CITY OF ALBUQUERQUE

**Re: Children's Grief Center
4125 Carlisle Blvd. NE
60-Day Temporary Certificate of Occupancy
Transportation Development Final Inspection
Engineer's Stamp dated 4-13-21 (G16-D157)
Certification dated 2-29-22**

Prior to the issuance of a permanent Certificate of Occupancy, the following items must be addressed:

B1 SITE PLAN
1" = 20'-0"

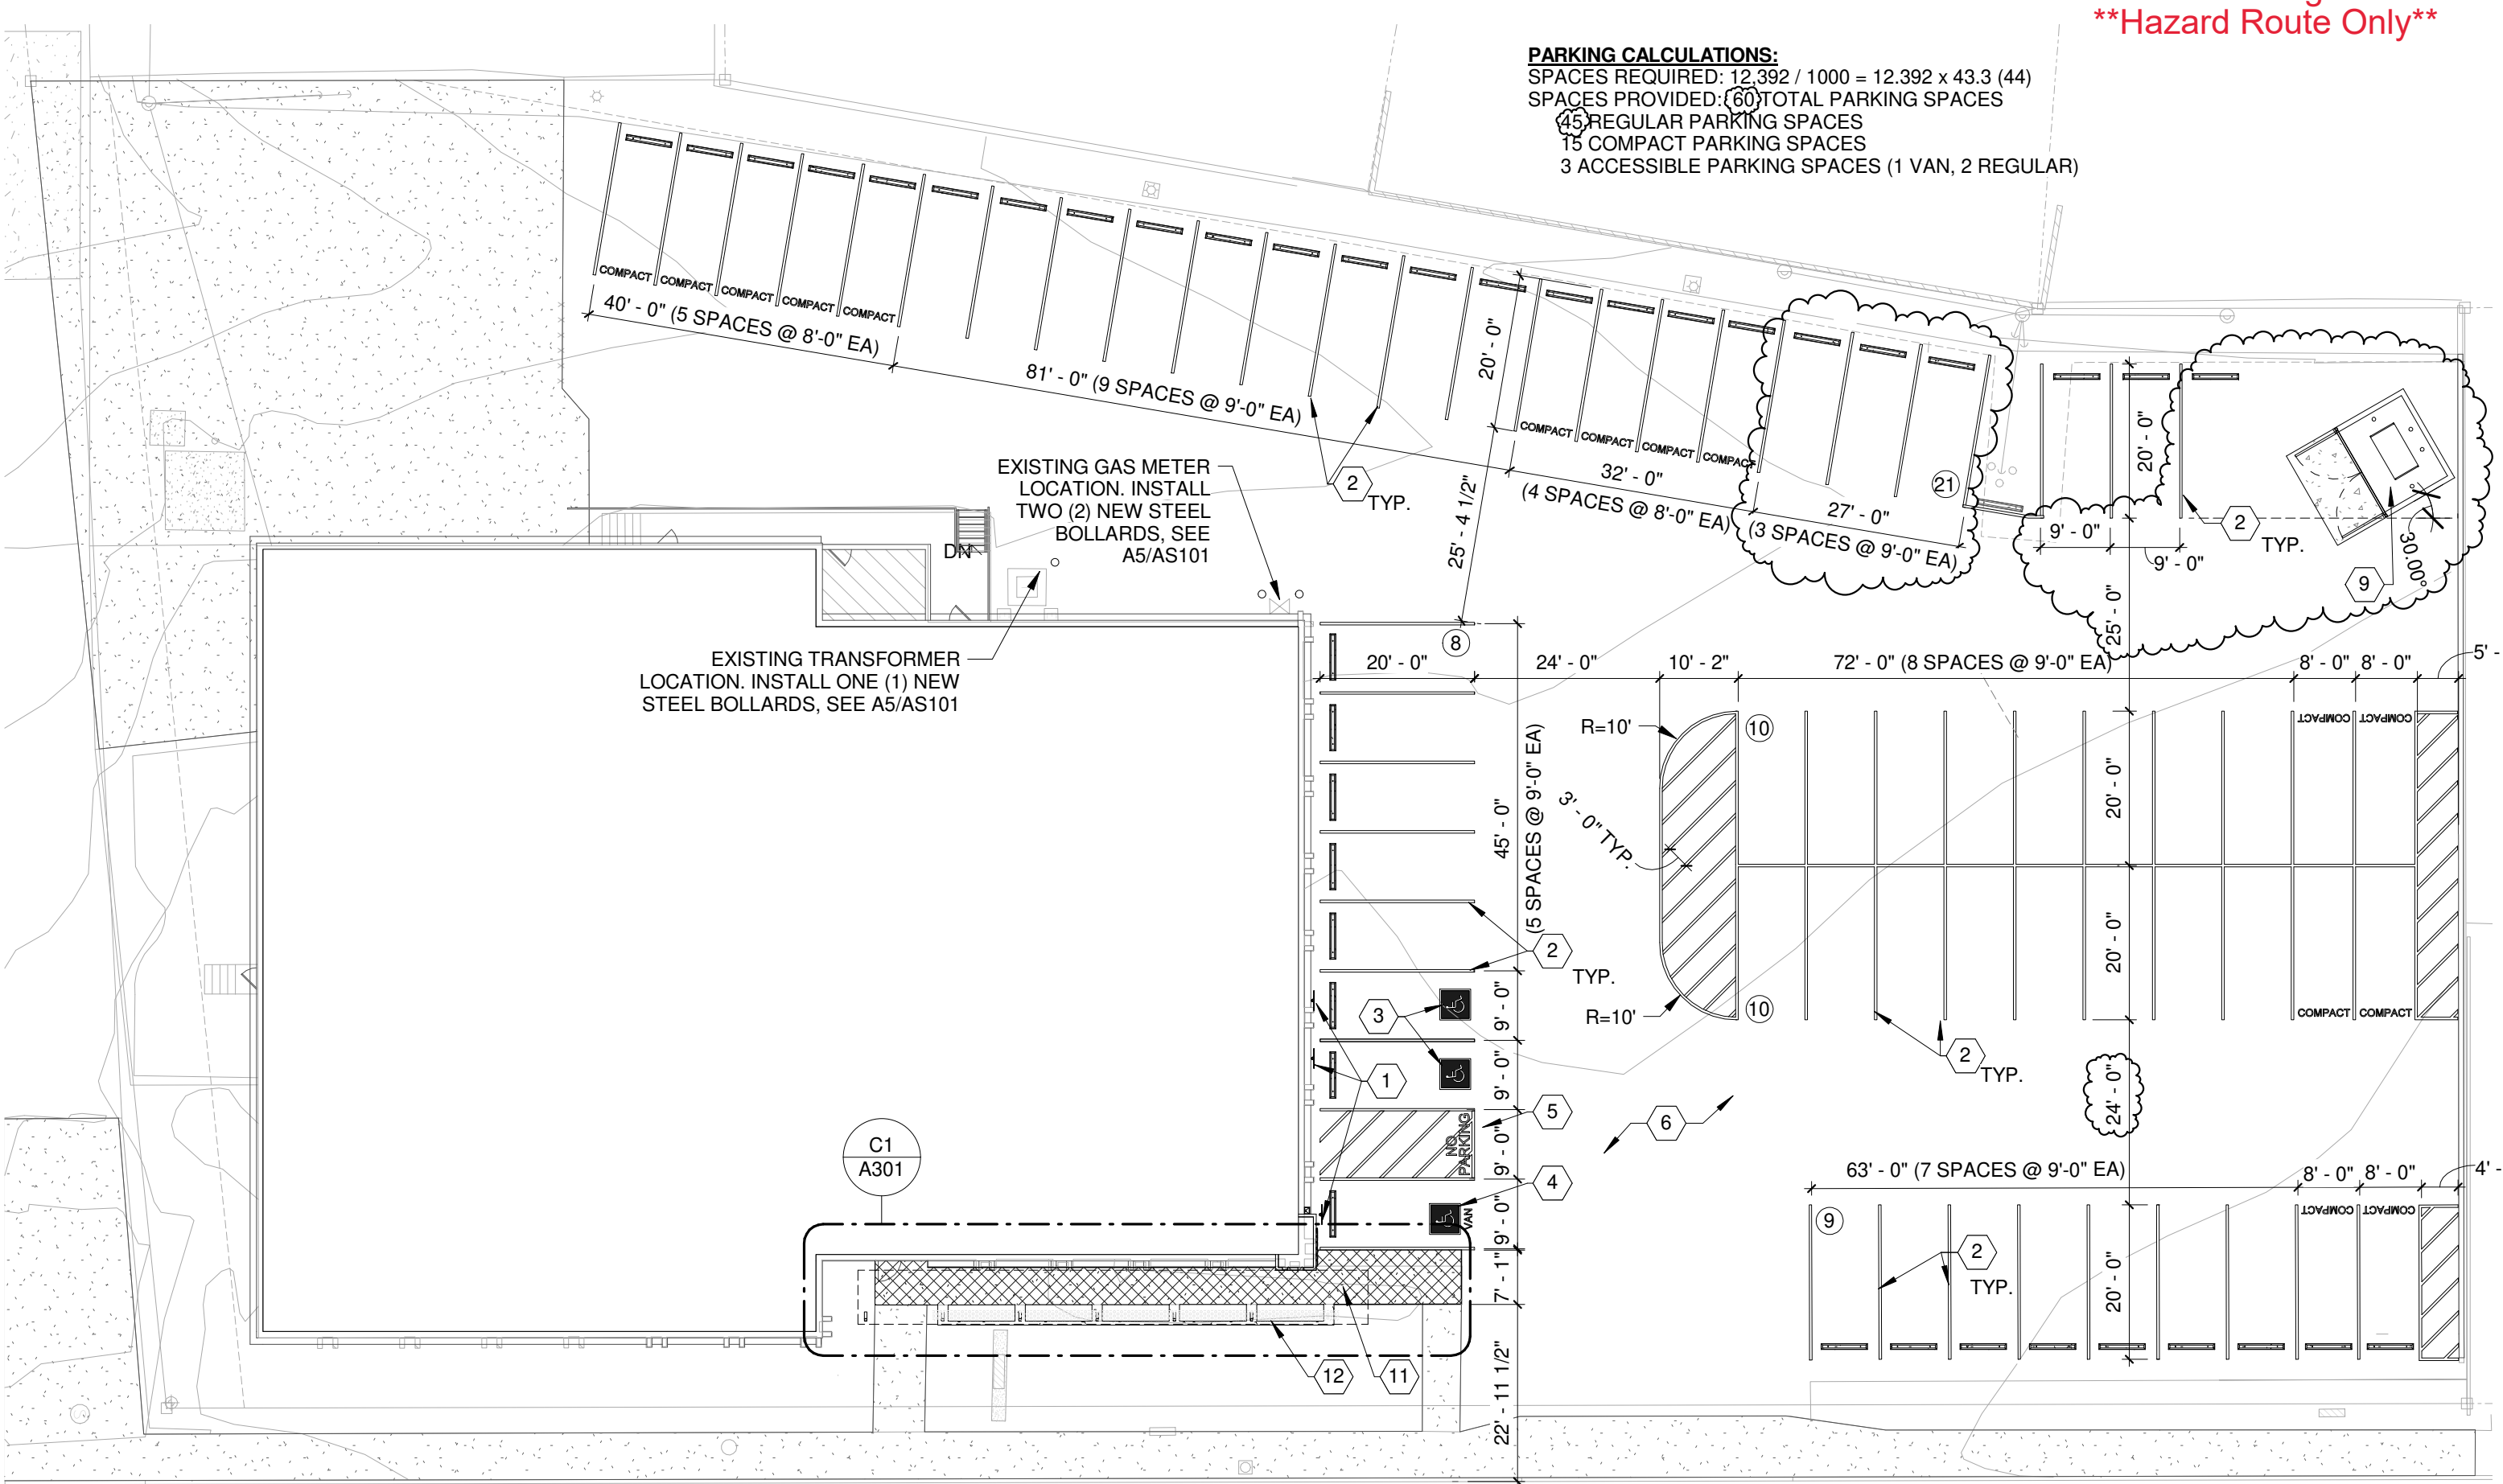
- Parking area must be built per Approved site plan.
- Provide a copy of the existing COA Easement.
- Remove construction equipment and debris from site.
